From: Daun Johnson on behalf of Planning.Responses
Sent: 15 February 2018 09:27
To: Planning Scanning
Subject: FW: Planning Consultation on: FG/174/17/PL

Comment from Greenspace

APPLICATION **FG/174/17/PL**

Site Address: 32 & 34A Sea Lane Ferring BN12 5DY

DRAWING TITLE
Proposed Site Plan, Location Plan
and elevation from south

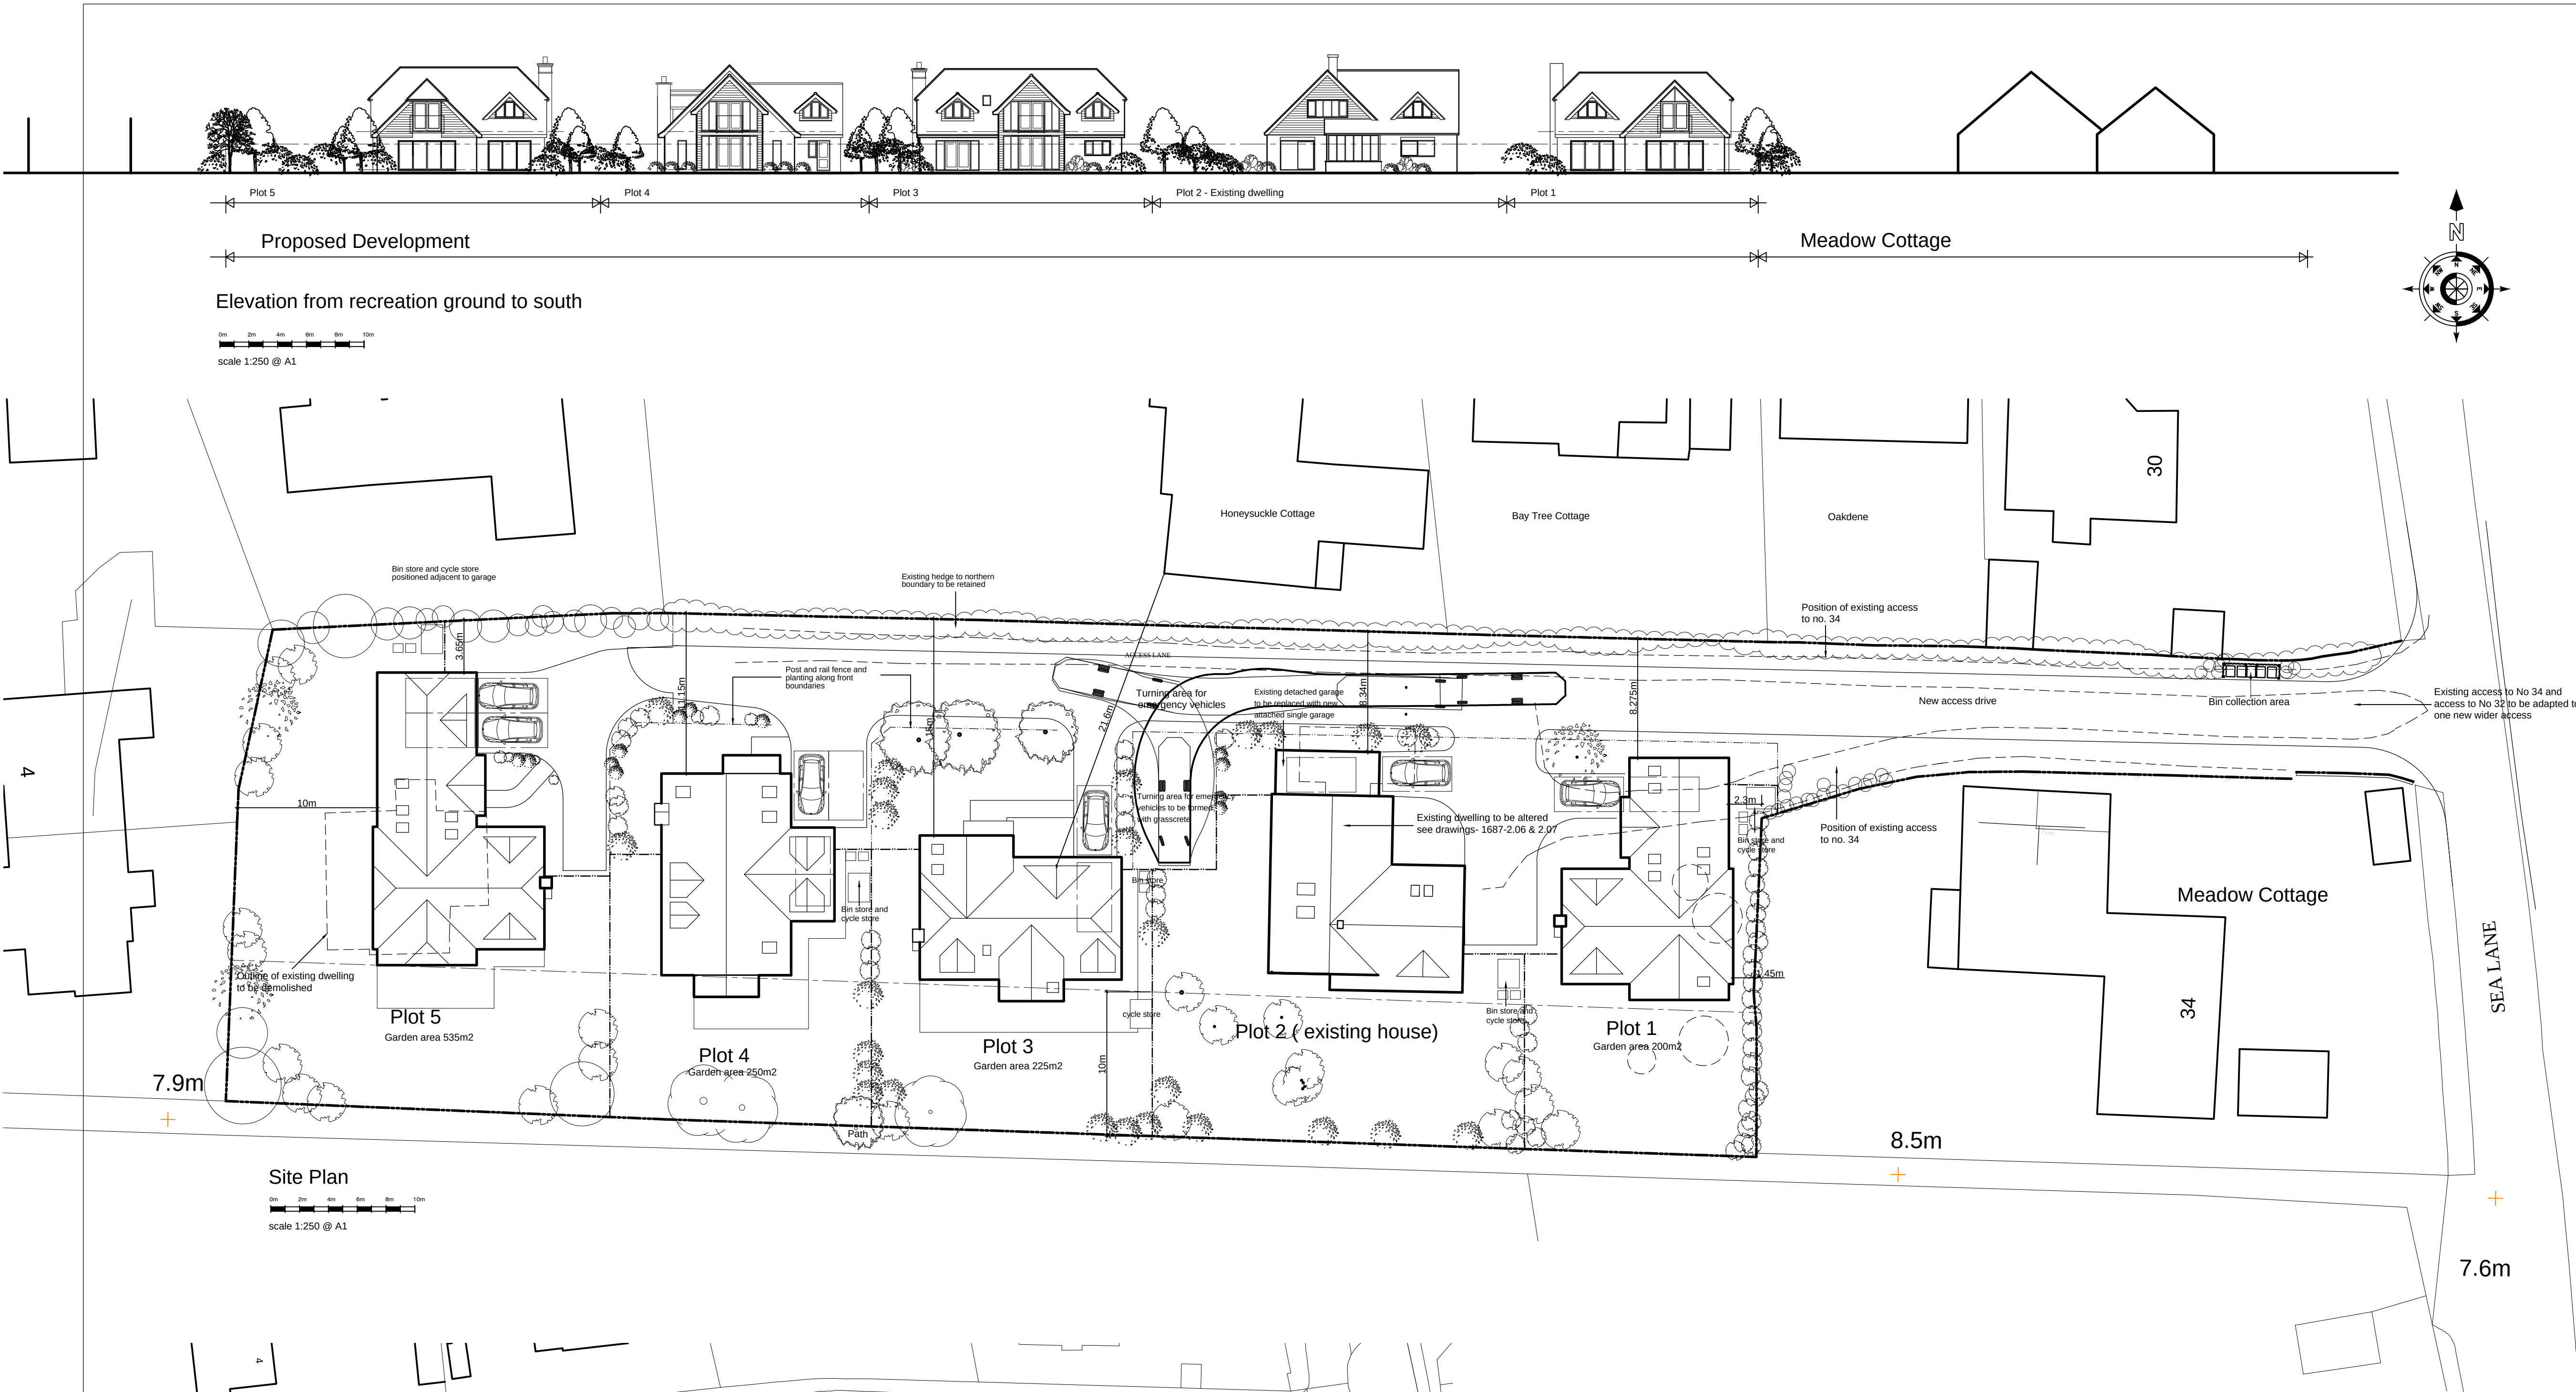
Forming part of the application and at least conditioned would be the requirement of the submission of a full landscape scheme which should be submitted for approval, detailing species choice, position, densities and size at time of planting. This should be plotted in plan and list form and in relation to the trees and vegetation to be retained in the locale, so that a clear picture of the proposals can be seen. These details are required to assure the proposals are appropriate to its setting and to ensure that appropriate screening is provided, maintaining and uncompromising the setting and ensuring that the proposals fit within the area of neighbouring and adjacent properties.

Any trees or vegetation that fall within the proposed or periphery of the development, may provide significant aesthetic impact to the location. Any trees in particular along the boundaries, and we note trees in the location of the front garden to No 34 and also any that which adjoin neighbouring property could provide potential valuable screening and should be retained and protected. Any considered tree removal from this site should be agreed with Arun District Councils Tree Officer. Root protection Areas (RPA) should extend into the development site and to those in neighbouring land. Before construction, a tree protection scheme must be in place for any (If any) retained trees including trees whose root protection areas fall within the construction zone from neighbouring land. This should be in accordance with BS 5837:2012 'Trees in relation to construction' Any removed trees should be mitigated for.
